PRELIMINARY/FINAL DRAINAGE REPORT

**MIDTOWN COLLECTION AT HANNAH RIDGE
FILING No. 3**

PUDSP-20-007

Engineering Review

DESIGNED BY	KRC	SCALE	DATE	08/21/20
DRAWN BY	KC	(H) 1"= 30'	SHEET	1 OF 1
CHECKED BY		(V) 1"= N/A	JOB NO.	1116.35

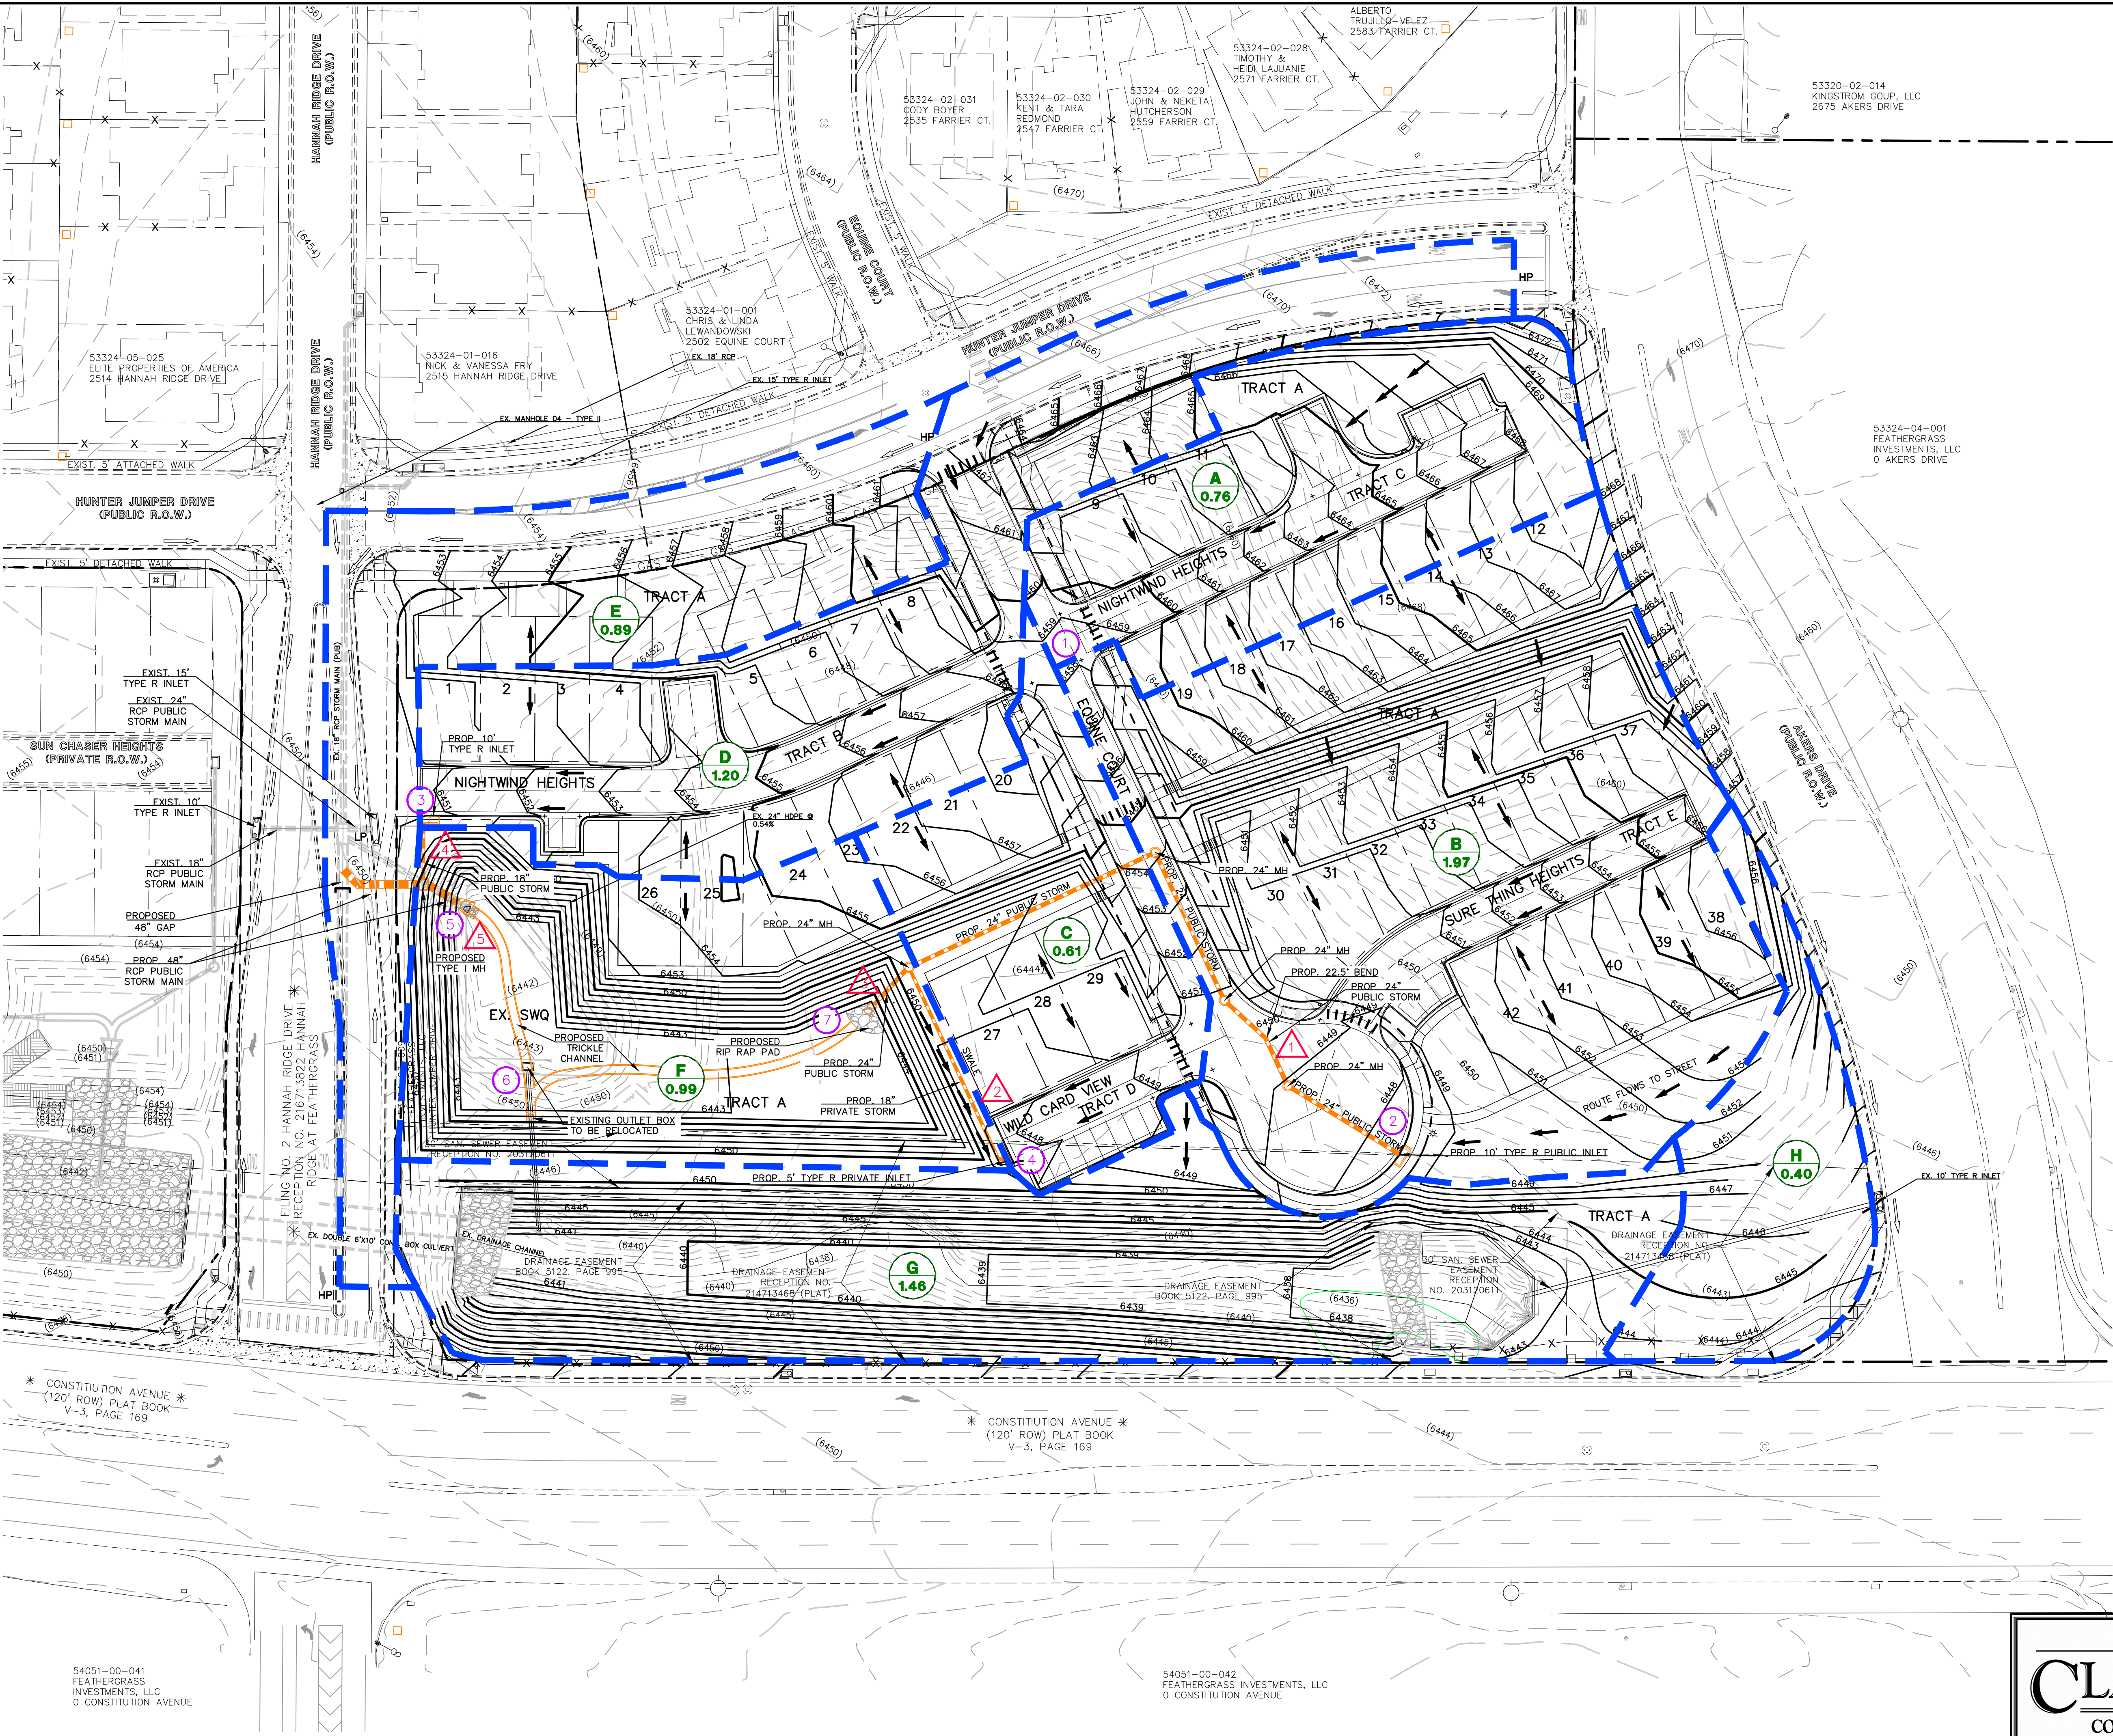
B-1?

1.7 cfs per Surface routing spreadsheet.

Pipe routing spreadsheet shows DP 5

Basin B-2 does not show a design point on the drainage map.

At Tract A, leading into the pond, there is a ridge line, so how does any overflow cross over the ridge and into the pond? From grading, looks like area is more likely to end up in drainage ditch along Constitution.

Discussion of DP's 5 & 6?

← E?

What are the flows generated by these basins?

sheet?

Include discussion of all basins offsite that contribute and acreage & % impervious they are.
